From: Clare Dales
Sent: 21 March 2018 09:41
To: Anita Gardner
Subject: RE: 15-122 - Littlehampton Market - app ref LU/390/17/PL

Thank you for inviting me comment on revised plans. The revised plans differ from the previous iteration in that the roofscape has been revised. Although the ridge line has been reduced, it still exceeds that of the neighbouring property, and thus continues to dominate it and adversely affects the general rise in roof line proceeding up Surrey Street. The reduced ridge line has resulted in the addition of dormers to accommodate the second floor flat. It is considered that these represent an alien intrusion, and is not supported on heritage grounds.

Proposed Plans And Elevations

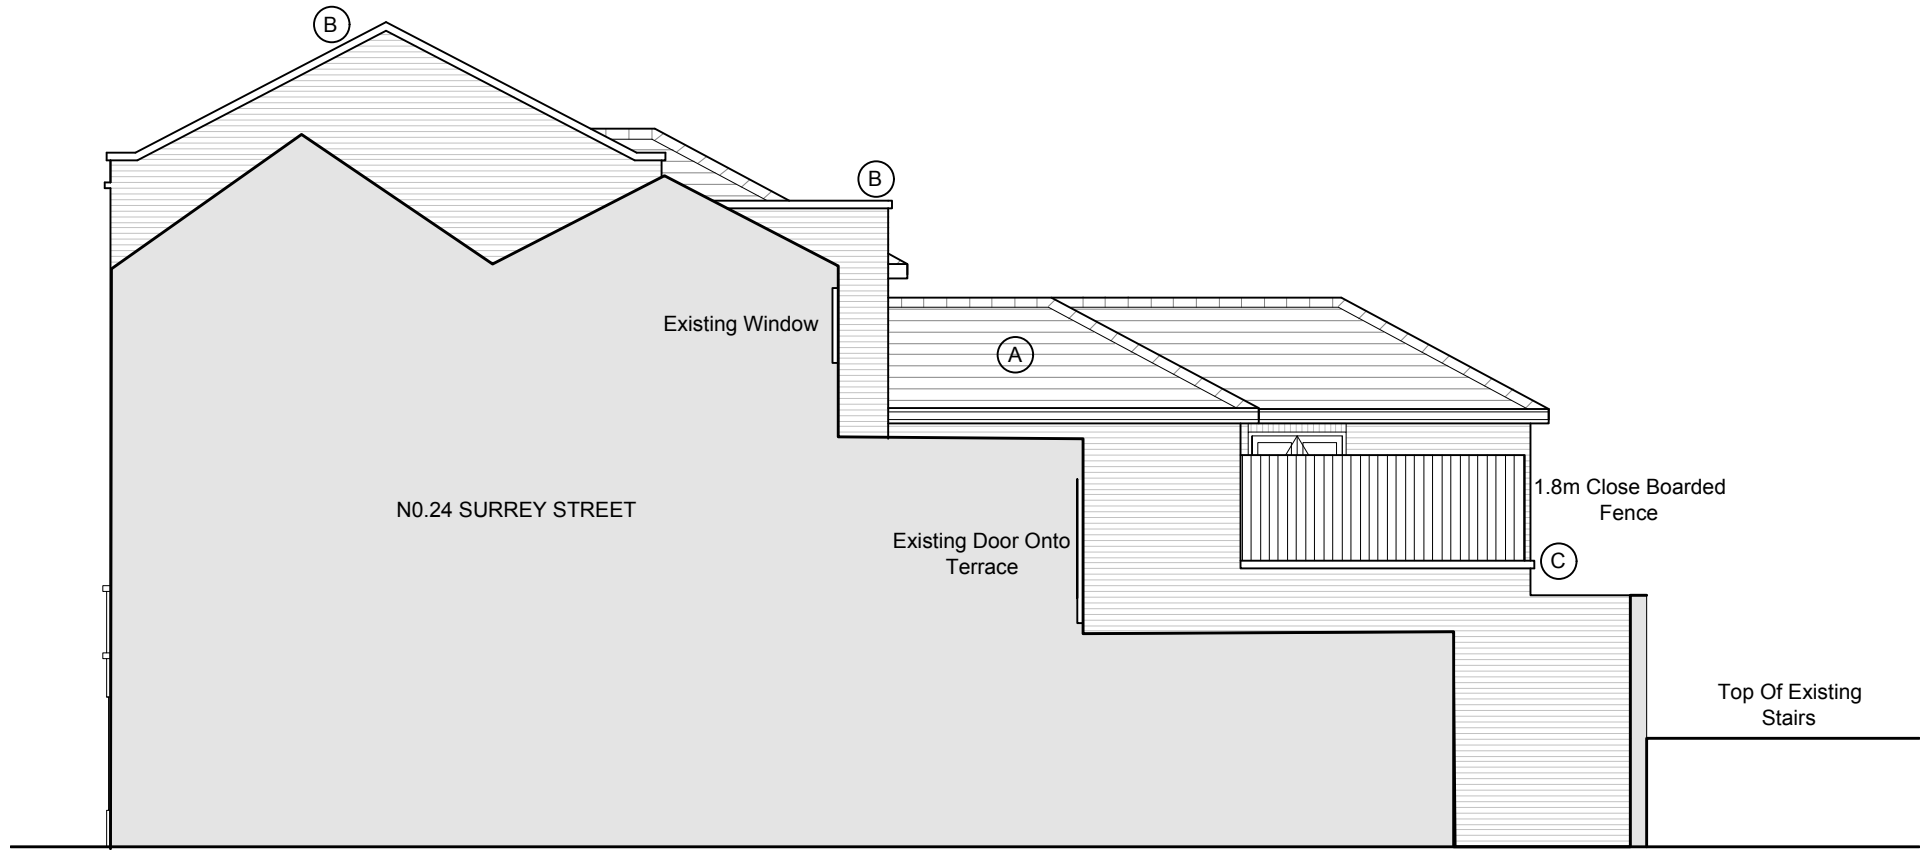
If the scheme were reduced to two storey (GF Shop plus FF flat), with a reduced roofline, a scheme may be acceptable, however it would still result in the loss of an attractive flint building, which contributes to the street scene.

In response to your email below advising that details of the proposed submission are not considered acceptable to the LPA, I now attach revised plans demonstrating a much reduced roof mass to the new building fronting Surrey Street. I note your comments concerning the hierarchy of the built forms here, and trust that this altered proposal now meets your approval.

Having discussed the matter of proposed materials with the applicant, Hyde Housing, they have confirmed that genuine slates to the roof, lead to the curved dormer windows, and timber sliding sash windows would be acceptable as proposed materials.
